From: Nicola Moore
Sent: 31 March 2021 10:28
To: 'Tom'
Subject: RE: AW/104/21/PL - Proposed works at 97 Aldwick Road Aldwick PO21 2NY

Drawing No.	Date:
D.1091 - 06	04-03-21
Rev.	Date:
A	27-03-21

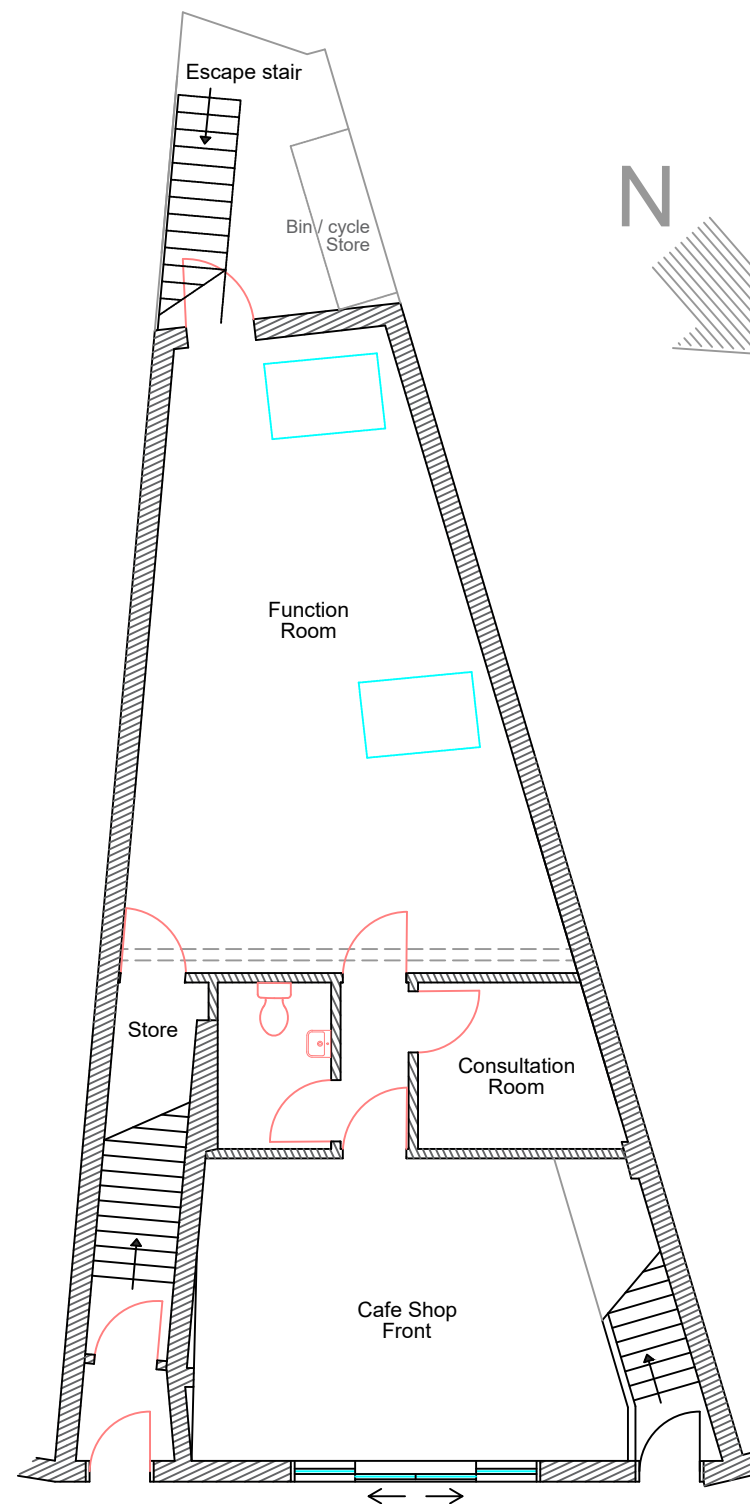
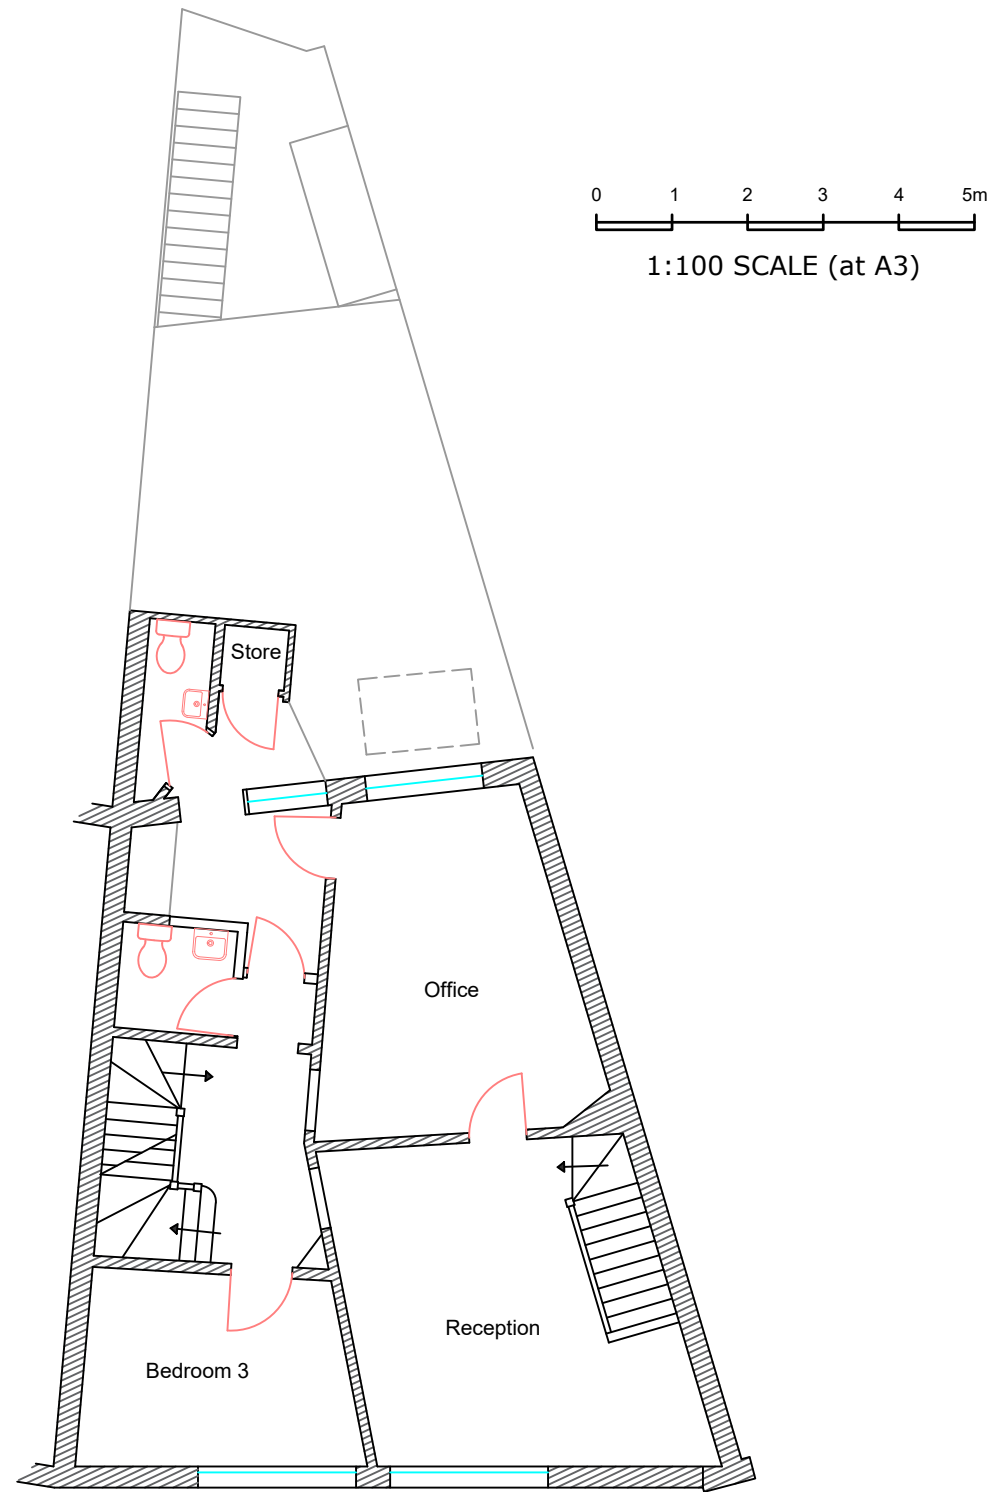
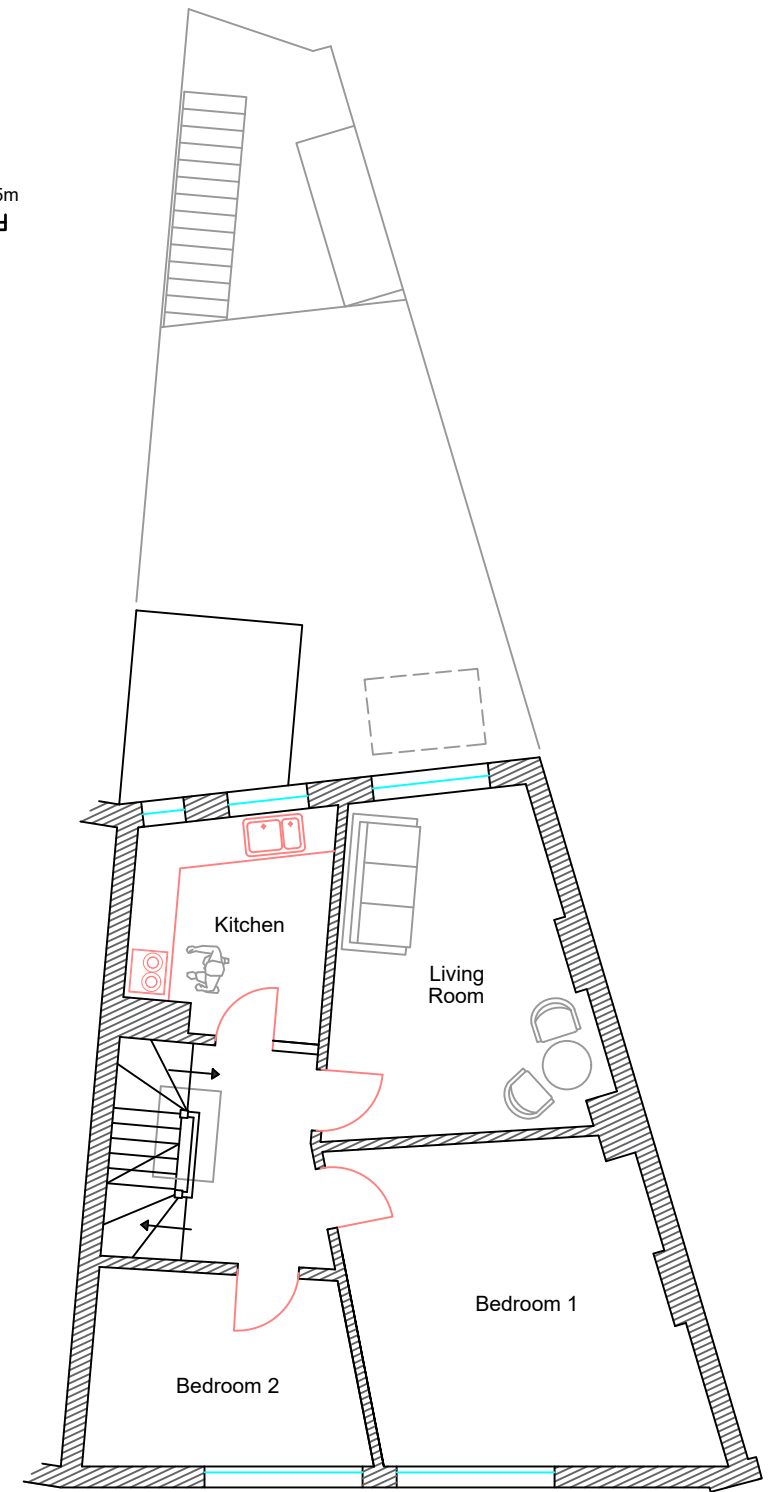
The proposed floor plans show 2 x Bedroom 2, please amend accordingly and re submit CIL Additional Information Form

My apologies, Please find attached a revised drawing which shows Bedroom 3 not Bedroom 2. The proposed development does not increase the number of bedrooms compared to existing and the residential floor area is also the same (slightly less). Please see attached the CIL Form as requested.
